February 2, 2024

**Re: Dutch Bros Coffee**  
**2070 Gibson Blvd. SE**  
**30-Day Temporary Certificate of Occupancy**  
**Transportation Development Final Inspection**  
Engineer's Stamp dated 03-10-23 (M15-D021C)  
Certification dated 02-01-24

SITE PLAN

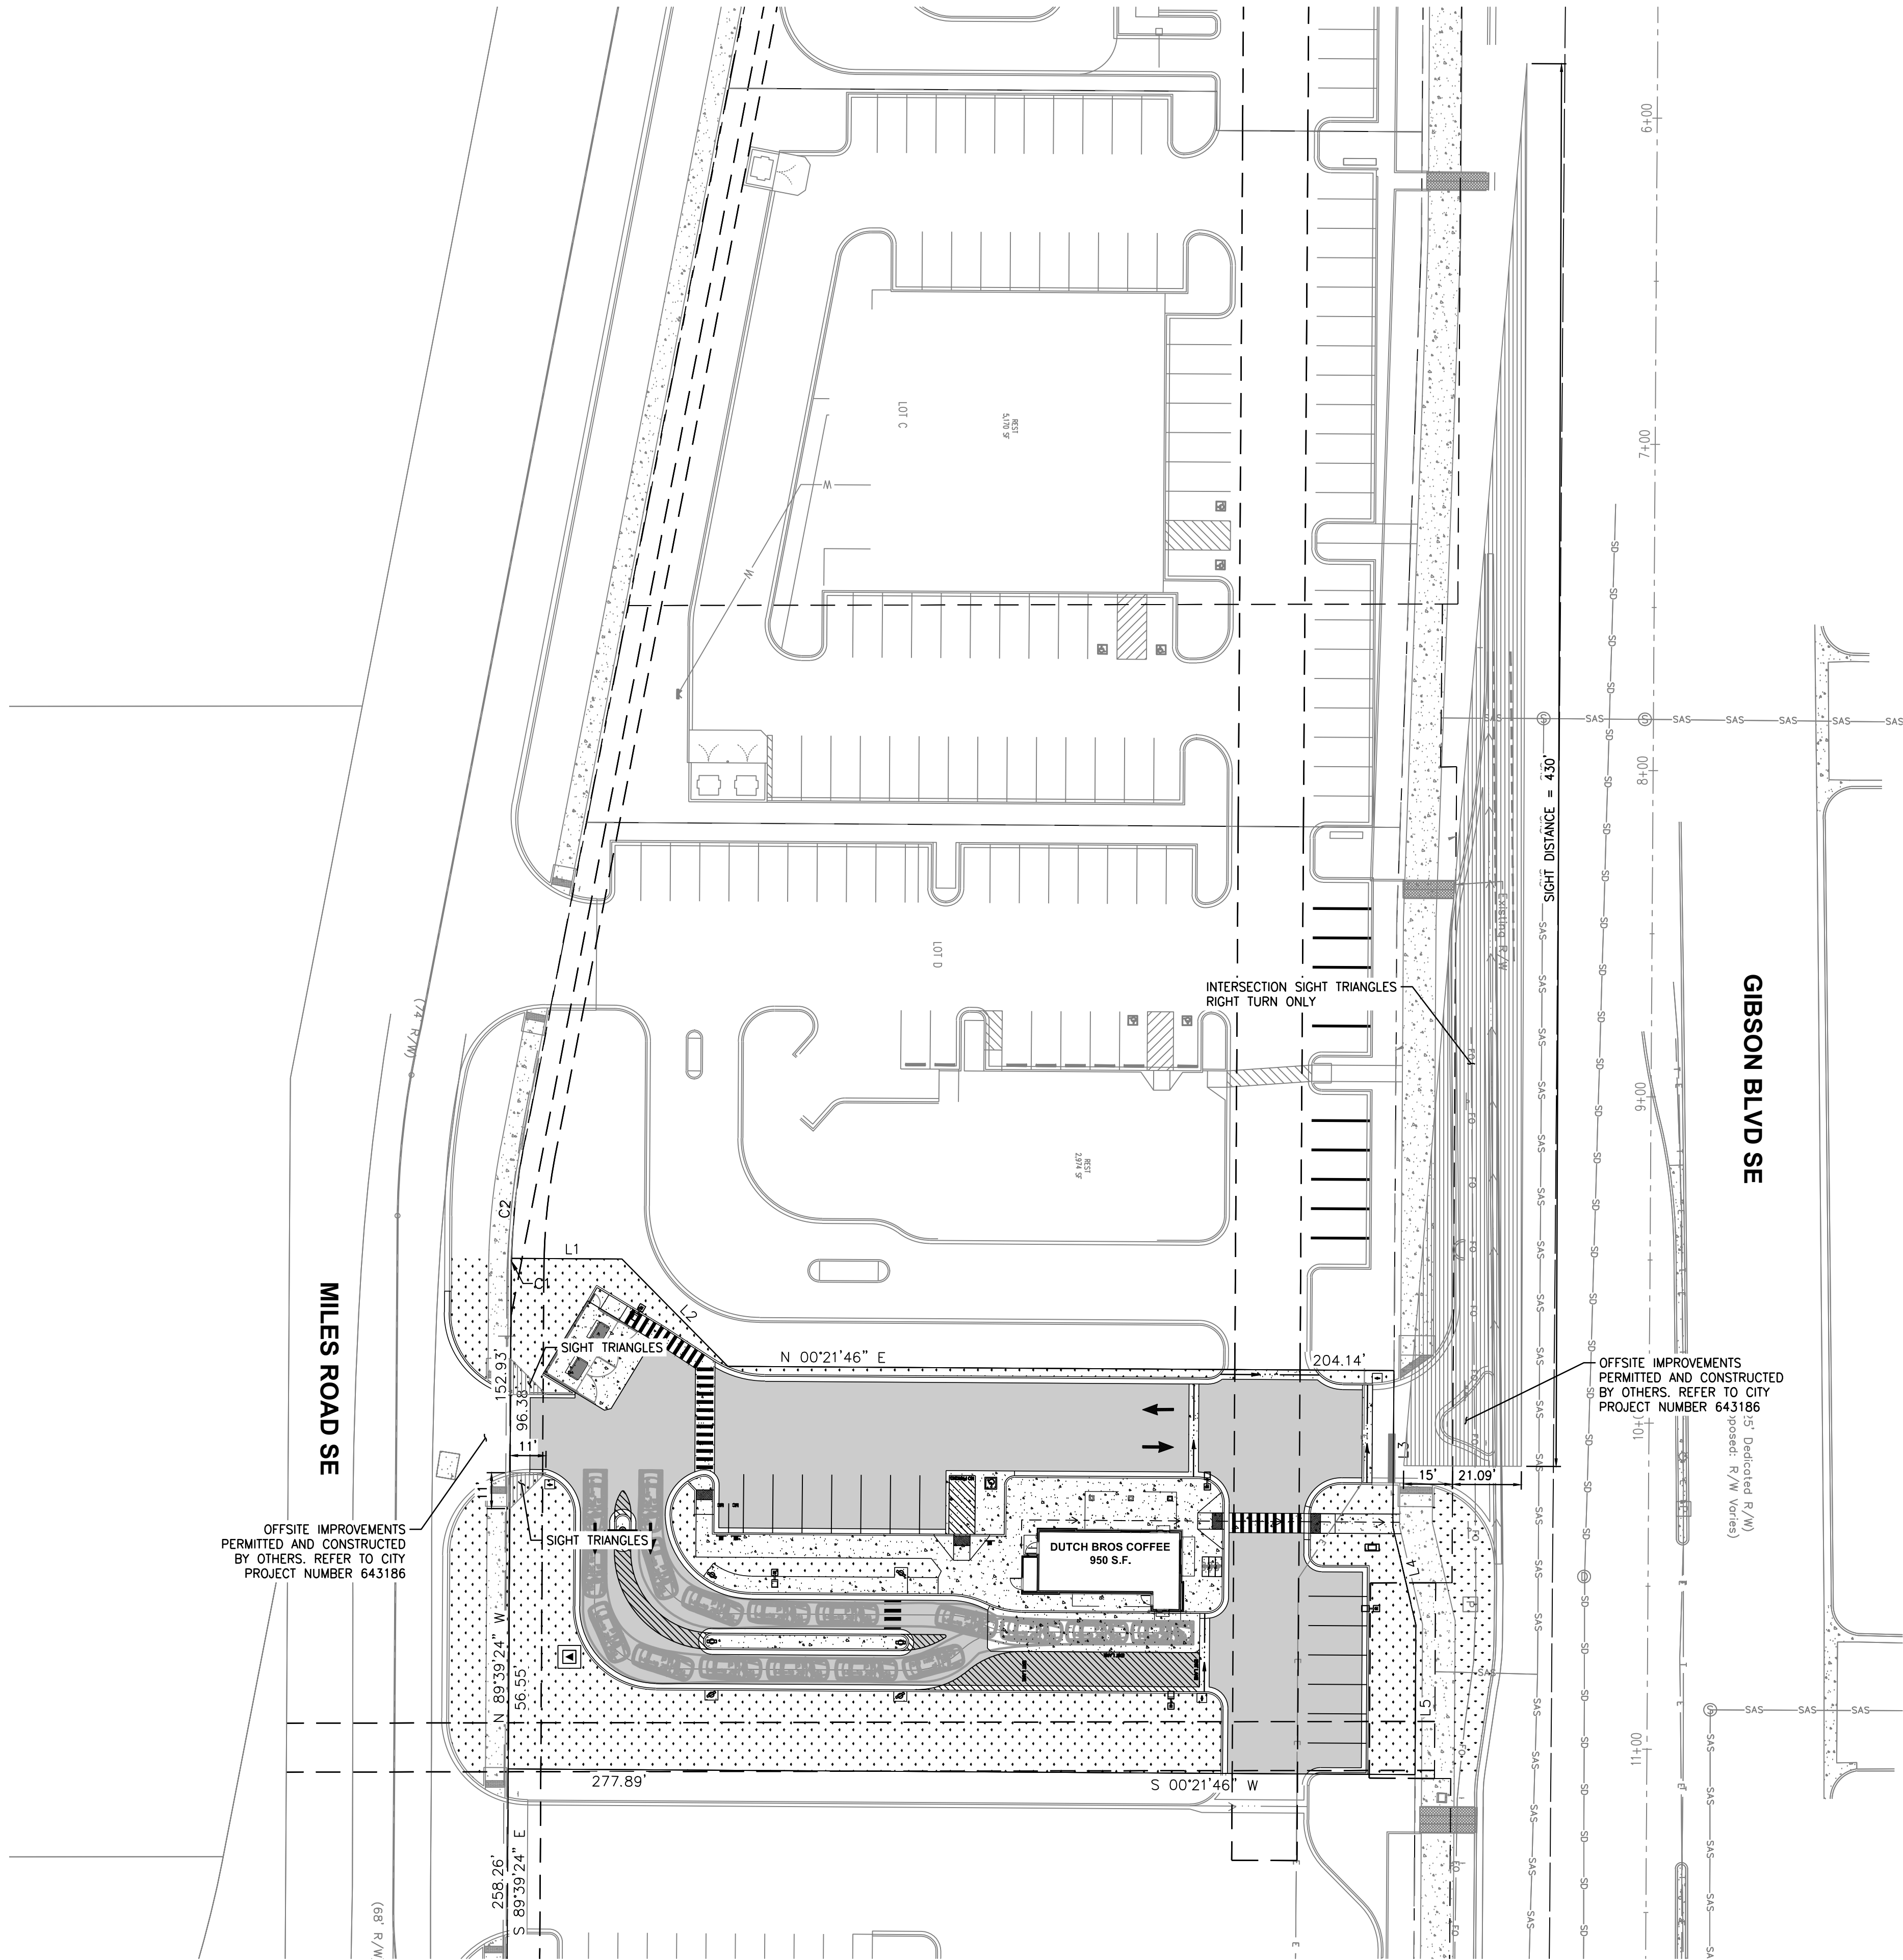
- Anchor down Bike Rack.
- Please remove all construction equipment from the site.
